CITY OF PORTLAND

BUILDING PERMIT

Located At 1199 CONGRESS ST

Job ID: 2012-06-4272-SIGN

1199 Congress St

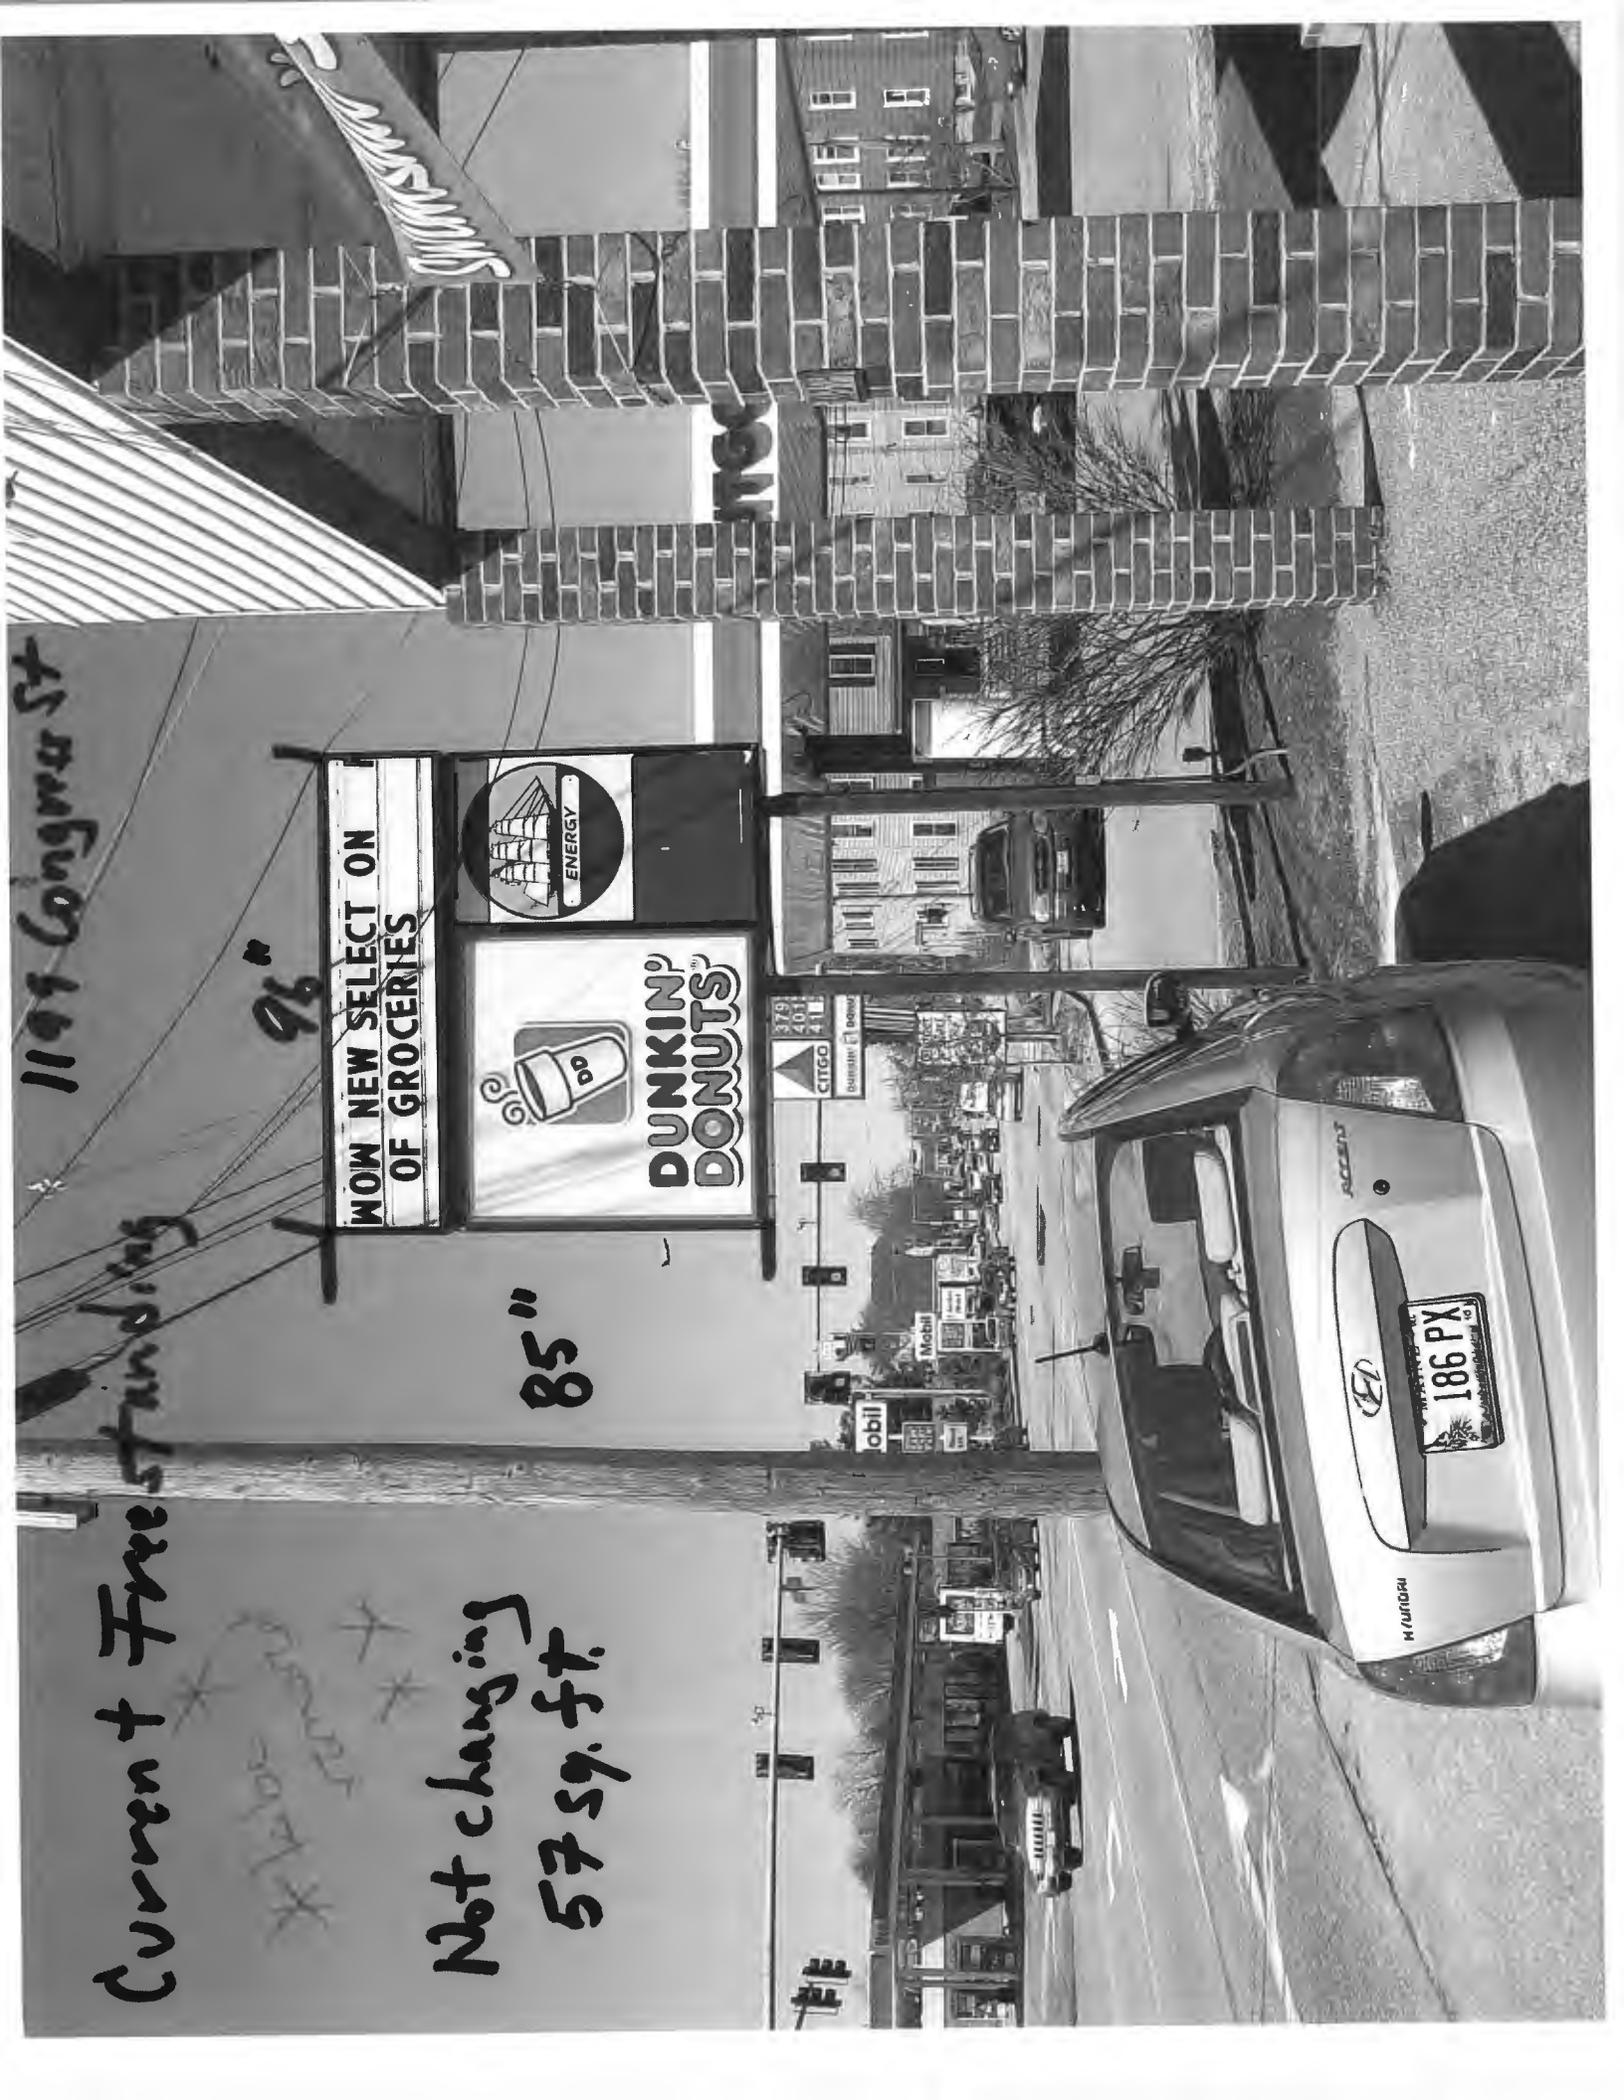
- The only sign that meets the ordinance is the wall sign - 30 sf is allowed & 23 sf is proposed
- Only one pylon sign is allowed per property. I researched the property and did not find permits for two pylon signs. The maximum square footage is 62 sf. The sign on the corner is 75 sf. One pylon sign needs to be removed and the remaining one needs to be in compliance.
- Two canopy signs are allowed but the maximum square footage per sign is 20 sf. Each proposed canopy sign is ~~48sf~~ 24 sf.
- Signs on individual pumps are incidental and don't need to be permitted but a sign can't exceed 1 sf.
